From:
Sent: 21 July 2026 13:48
To: Katie Chew
Cc: DC Admin
Subject: Objection to Planning Application 2026/91657 – Plot 23, Lingards Road

1. The Committee report stated that the new dwellings fronting the north side of Lingards Road would be equivalent in height to, or marginally lower than, the existing properties on the south side.
2. The approved plans showed a 10-metre separation between Plots 23 and 34.
3. The approved development was described as comprising predominantly two and three-storey dwellings. The split-level design was specifically relied upon to keep the buildings lower and reduce their apparent mass.

Figure 1 - Annotated extract identifying plan contradictions

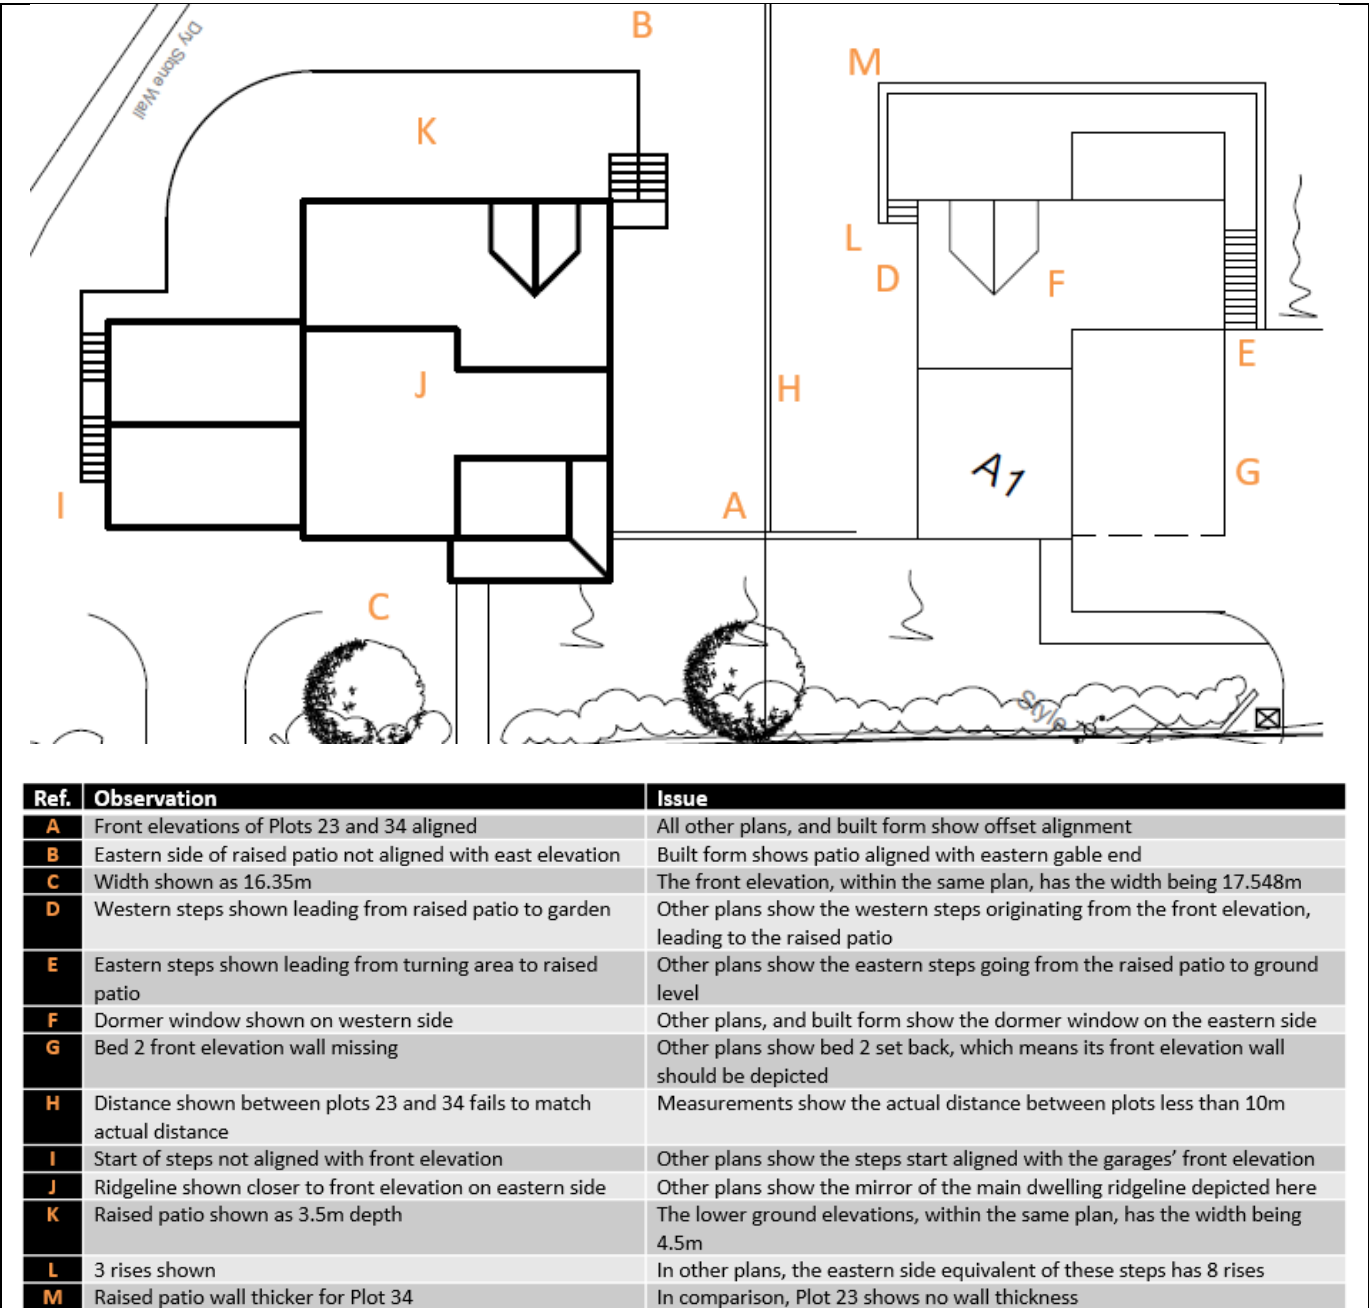
Plot 23 has been constructed east of its approved position. Its footprint also corresponds with the larger version shown on the Grouped Plans and Elevations, which is approximately 7% wider than the footprint depicted on the Site Plan.

The displacement and enlarged footprint also appear to have reduced the approved separation between Plots 23 and 34. The approved plans showed a clear 10-metre gap. The Council should establish what separation has actually been provided and expressly disclose that measurement.
